**Re:** Third Floor Plan/Nissen's Building

I have commenced the review of the above project and have the following comments:

3RD FL

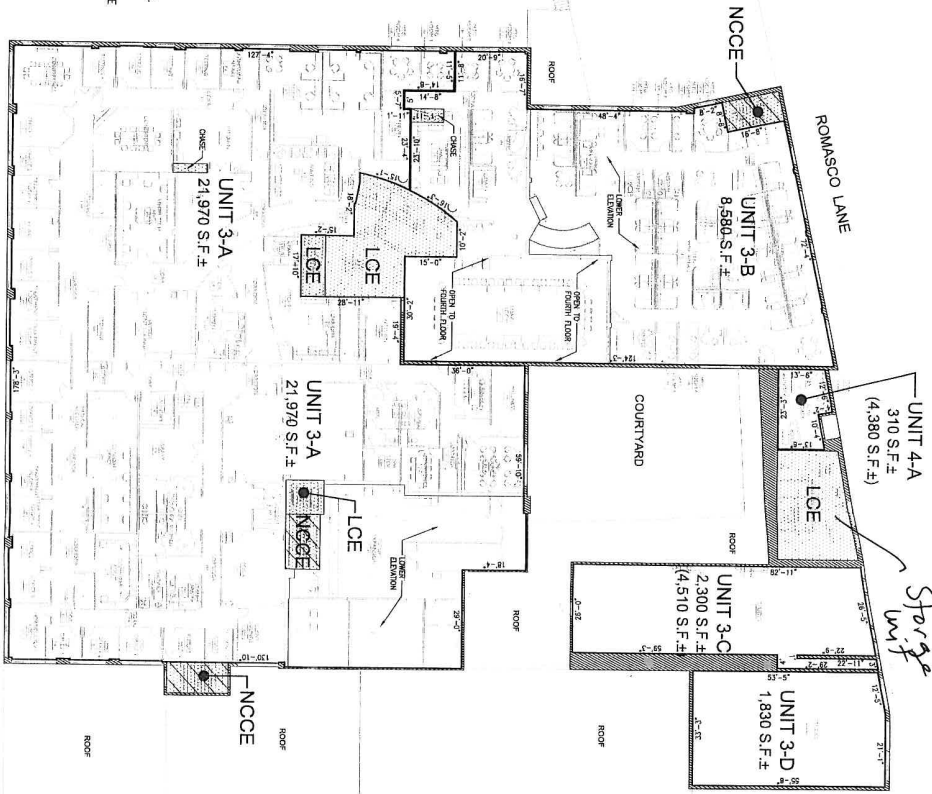
- 1) Please Provide all available plans and specs for this project.
- 2) The Large conference room appears to have non-compliant egress based on the potential occupancy load (80).
